Epping to Thornleigh Third Track Proposal. Application number SSI 5132.

I/we object to the Epping to Thornleigh Third Track Proposal and consider that the EIS is inadequate and does not address the full impact of this proposal. It will cause untold damage to the health of residents and to the fabric of the Beecroft Cheltenham Heritage Conservation Area. Do not approve this project, reconsider the alternatives and protect the community.

FIGURE 5.1e
 REVISED ETTT CONSTRUCTION IMPACT AREA
 PLUS VEGETATION COMMUNITIES AND
 RELEVANT HERITAGE ITEMS

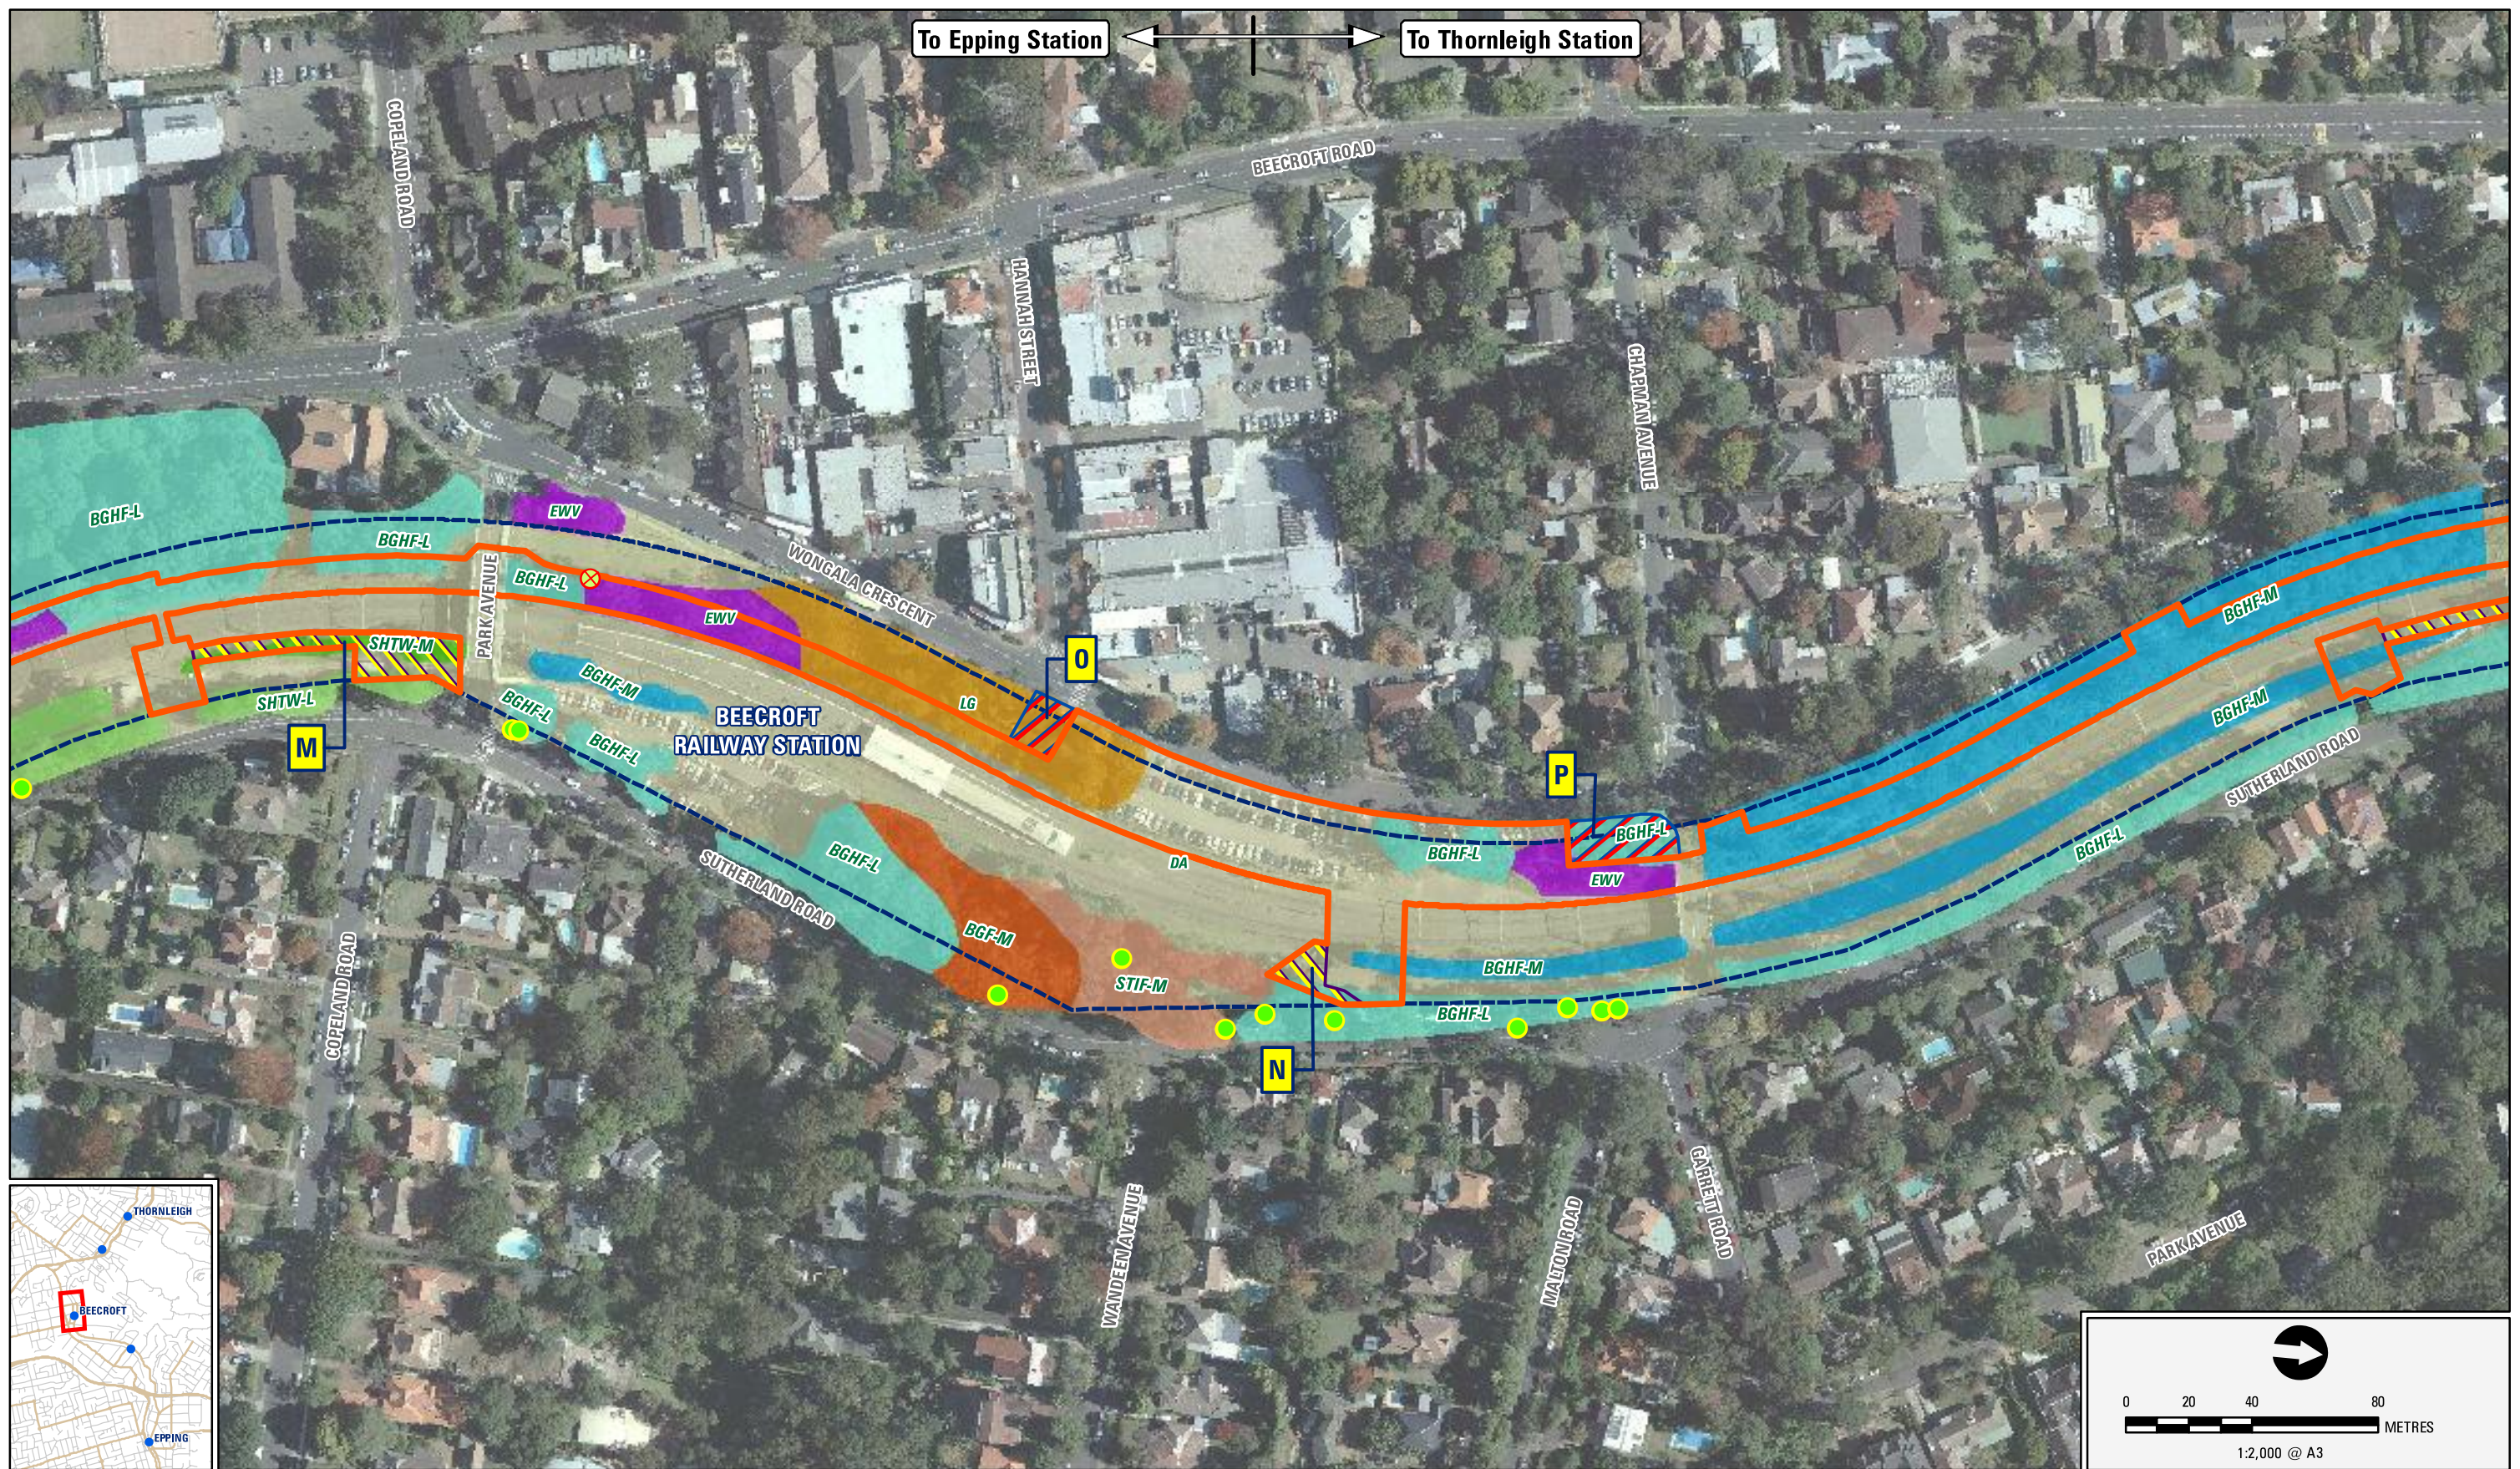
- There has been inadequate assessment of the project's impact on the fabric of the Beecroft Cheltenham Heritage Conservation Area (HCA).
- The plan given for Beecroft Railway station Precinct is vague. The relationship to the trees, playground and original 1895 platform located south of the present station is not shown. A fourth track is shown on the eastern side. The plan does not include urgently needed lifts to allow disabled access at Beecroft Station.

- Beecroft Station Gardens have a heritage listing with Hornsby Council but the impact on them has not been adequately addressed. No arborist's report is given for the trees which will be removed.
